5 April 2019
Our Ref SU7340
Your Ref: SDD8699

**Redevelopment of Greenwich Hospital (Concept Proposal) at 97-115 River Road
Greenwich (SSD8699)**

I refer to your Notice of Exhibition dated 11 February 2019 and accompanying two volumes of the Environmental Impact Statement (EIS) in relation to a Development Application for the Redevelopment of Greenwich Hospital (Concept Proposal) (SSD8699).

DRAWING TITLE:
SITE SECTIONS
DATE:
AUGUST 2019
DRAWN:
ML, JC
PROJ:
1213
PROJ ARCH:
BF
DRAWING:
S.04
SCALE:
As indicated @ A1
REVISION:
P5

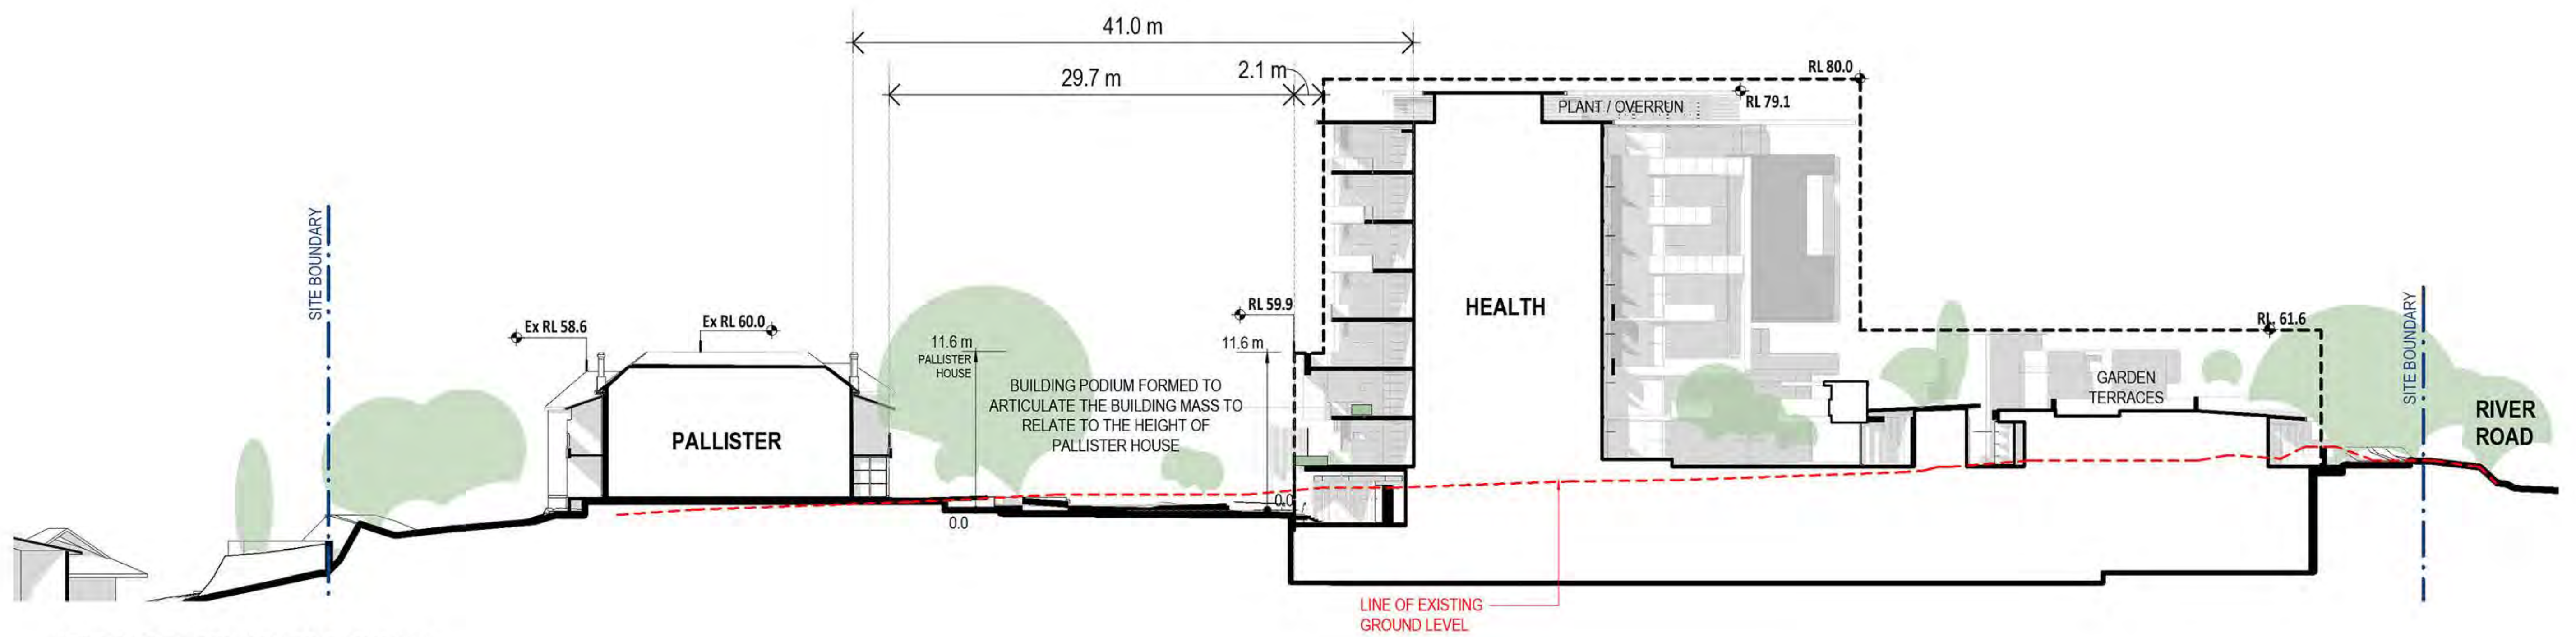
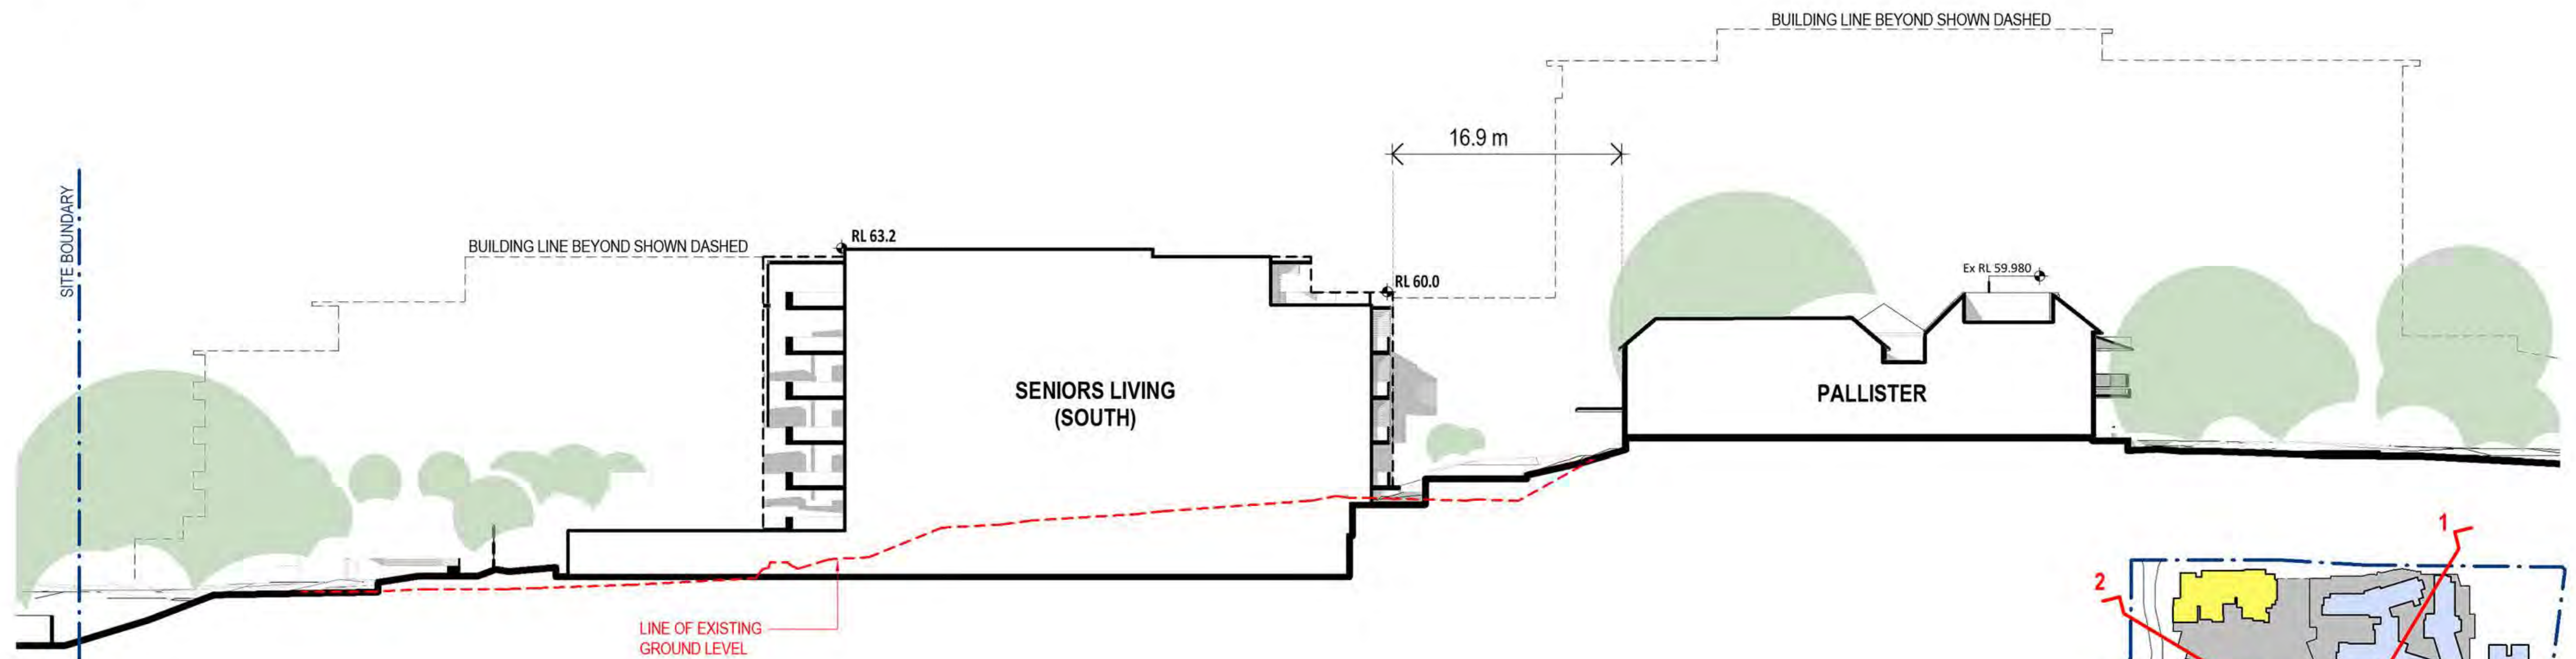
The nine-storey hospital building is proposed immediately to the north east of *Pallister* house and is separated by a car park and internal road. The building comprises a podium with basement parking and seven floors above. It is considered that the new hospital building would have a negative impact on the heritage significance of *Pallister* house and its setting.

The high-rise vertical facade of the southern elevation would dominate the curtilage of *Pallister* and create overshadowing during the morning period. The building is of an unprecedented scale in the vicinity of the heritage building. The height and massing of the hospital are incompatible with *Pallister*, exacerbated by its close proximity to the heritage building.

The Heritage Impact Statement (HIS) by NBRIS also refers to potential impacts of the Hospital:*The Hospital building will visually dominate the heritage item as it is a larger building with a closer relationship to Pallister than the existing hospital buildings.* The HIS makes no recommendation for the mitigation or management of the substantial impact of the new building and considers this impact to be acceptable.

The design of the new hospital building should be amended to reduce impact on *Pallister* house and its surrounding curtilage. This may be achieved by increasing the distance of the building from the heritage item and stepping back the south west facade at each floor level to reduce the massing and visual dominance of the building.

DRAWING TITLE: EXISTING TREES		DATE: AUGUST 2019		DRAWN: EC		PROJ ARCH: BF		SCALE: 1: 500 @ A1	
				PROJ: 1213		DRAWING: S.10		REVISION: P5

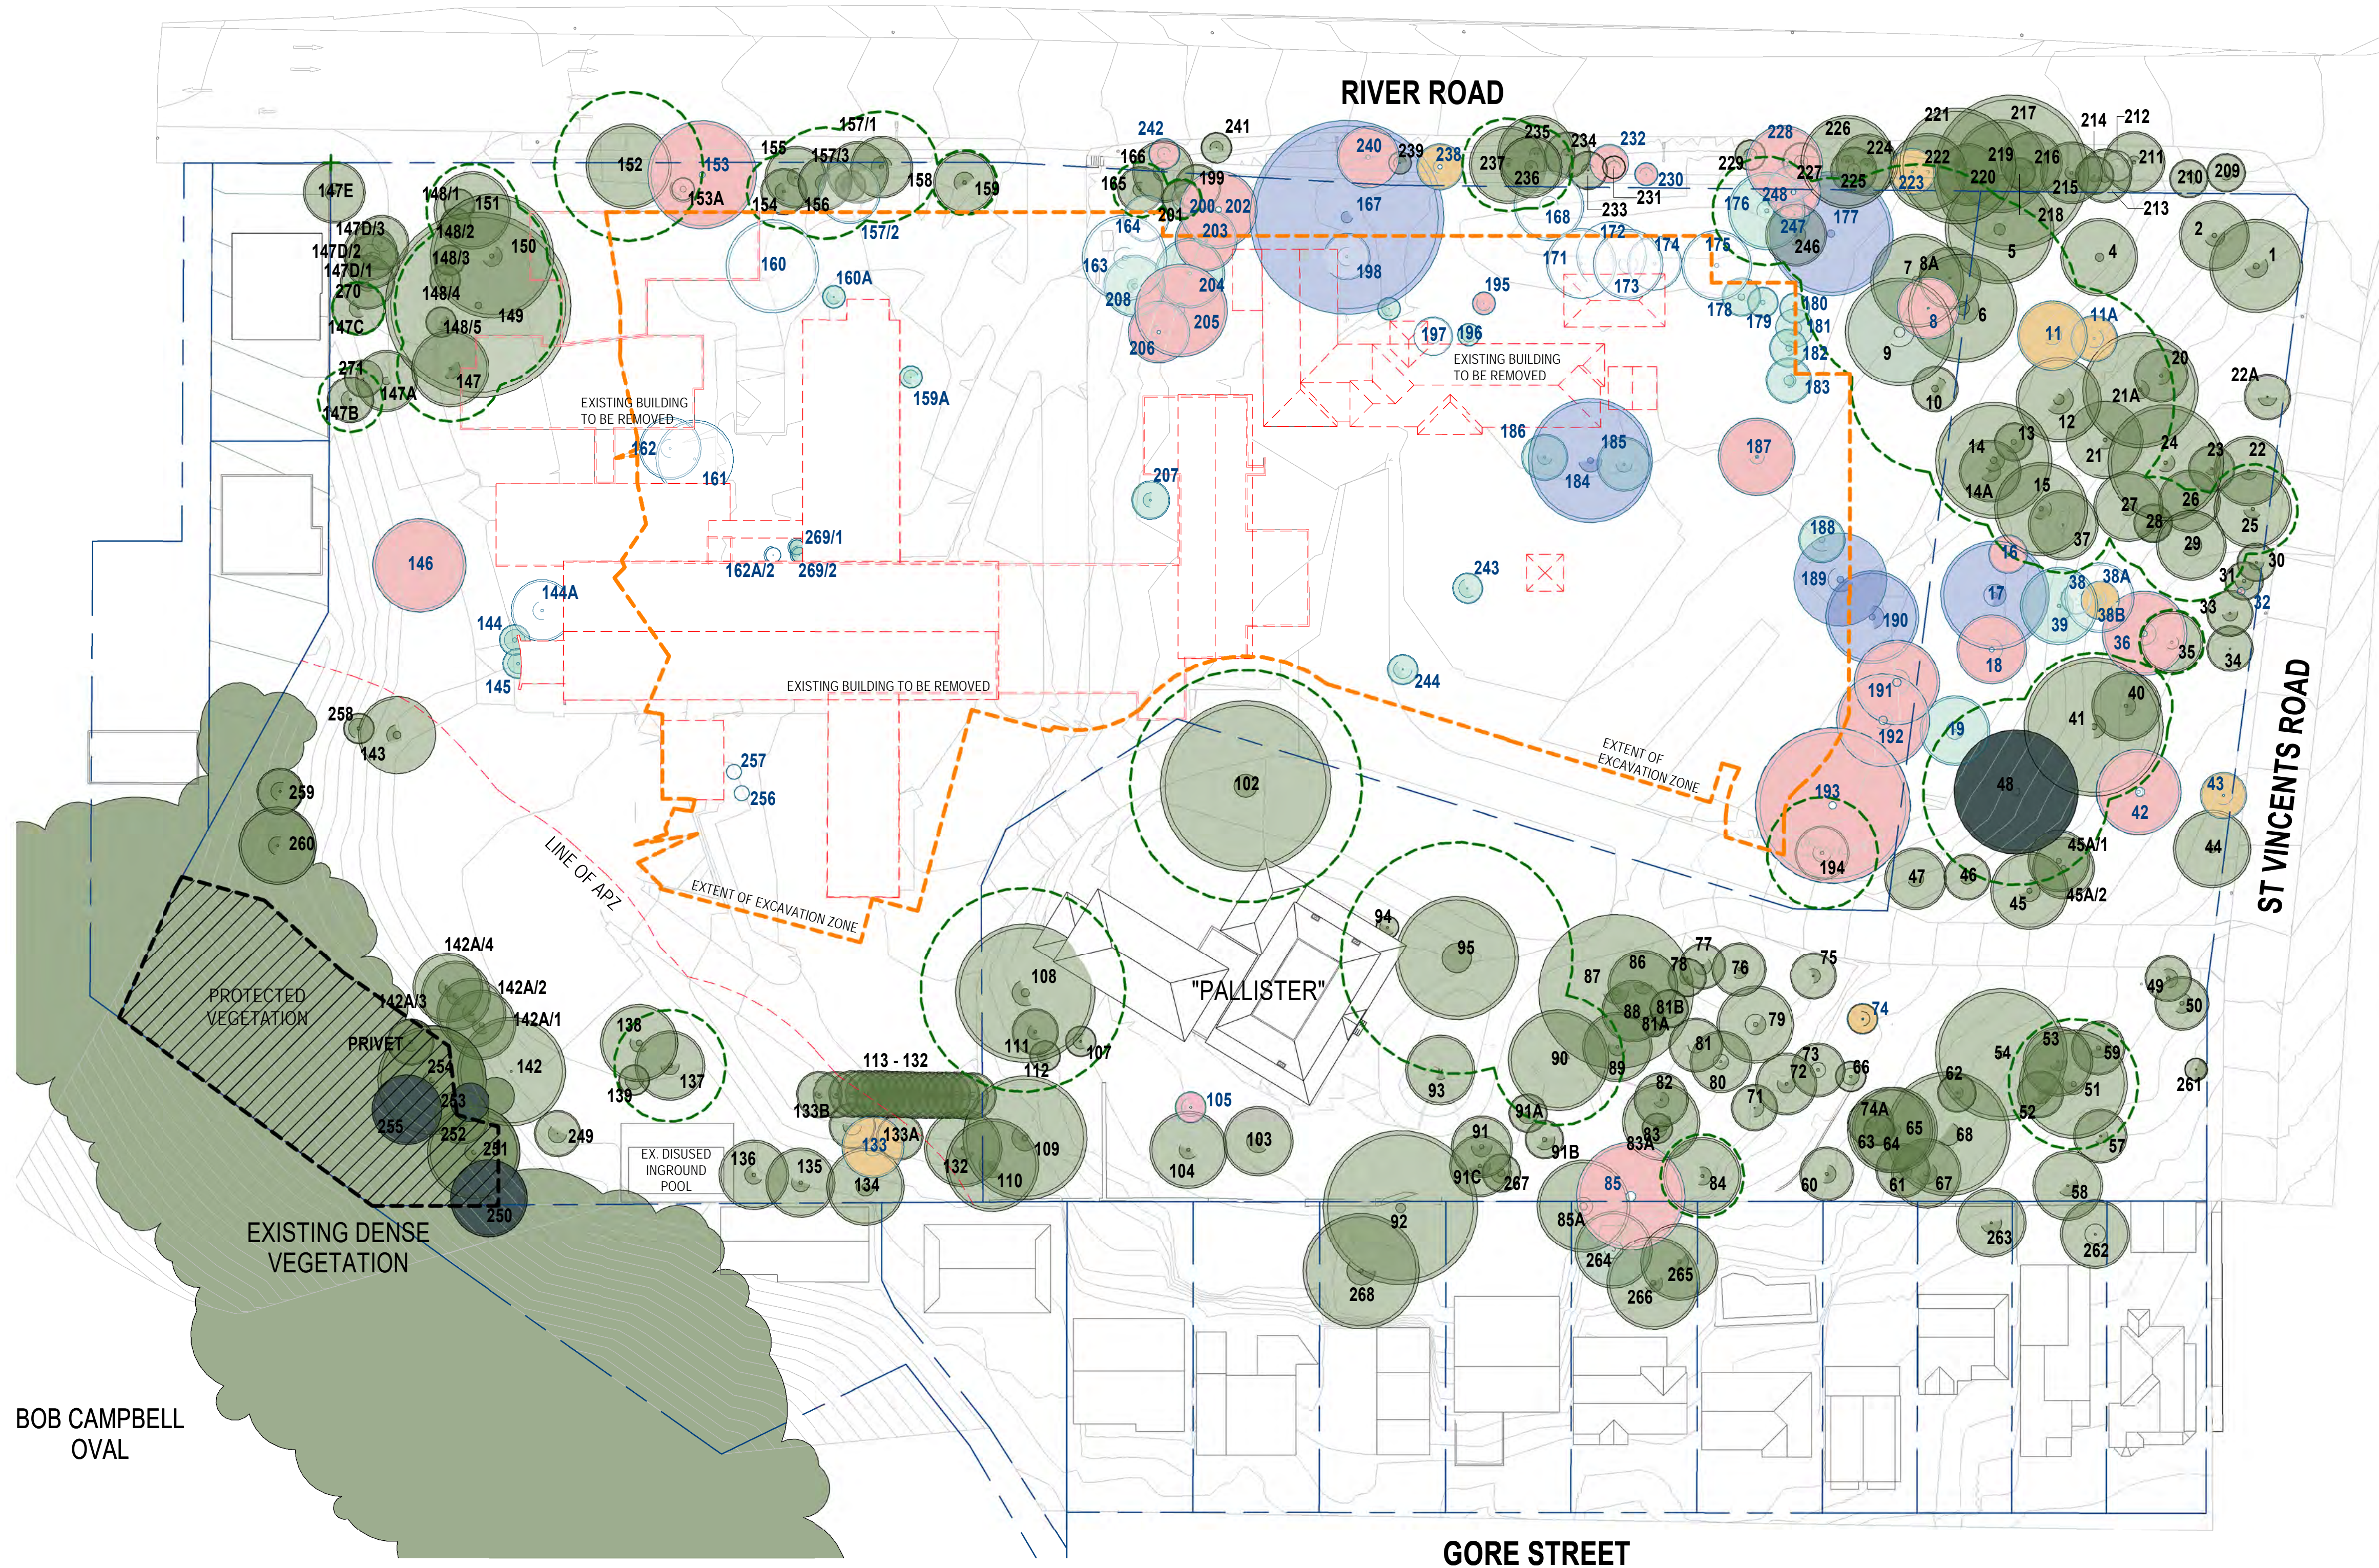
The proposed development would remove more than 50% of total tree canopy and is contrary to the North District Plan. The removal of 131 trees does not comply with the regional directives of the Greater Sydney Commission.

There are 235 individual trees located on and adjoining the site. A total of 131 of these have been proposed to be removed to facilitate the proposal, the remaining 104 have been proposed to be retained and protected for the life of the development.

The report has not specified which trees of the 104 retained would be subject to minor or major encroachments (expressed as a percentage, low being equal to or less than 10% of the total Tree Protection Zone area). As a result, the level of construction impacts the retained trees would be subject to is unknown, rendering their potential for retention in question.

A significant number of those remnant indigenous trees within the eastern part of the site along St Vincents Road are to be removed. In this area, only 2 Red Mahogany trees are to be retained, only 4 Blackbutts and only 8 or 9 Sydney Red Gum trees (as there are inconsistent recommendations for tree 79). Among the trees to be removed, a number of trees identified in this report as high priority trees for retention (trees 64, 77 176, 184).

The report does not contain scaled site plans that identify the radius of Tree Protection Zones (TPZ) or Structural Root Zones (SRZ) in relation to the proposed development.

Given the volume of trees assessed in this report it is considered scaled site plans that overlay tree data (TPZ, SRZ and canopy spread) onto the proposed plans are essential in the accurate assessment of the development.
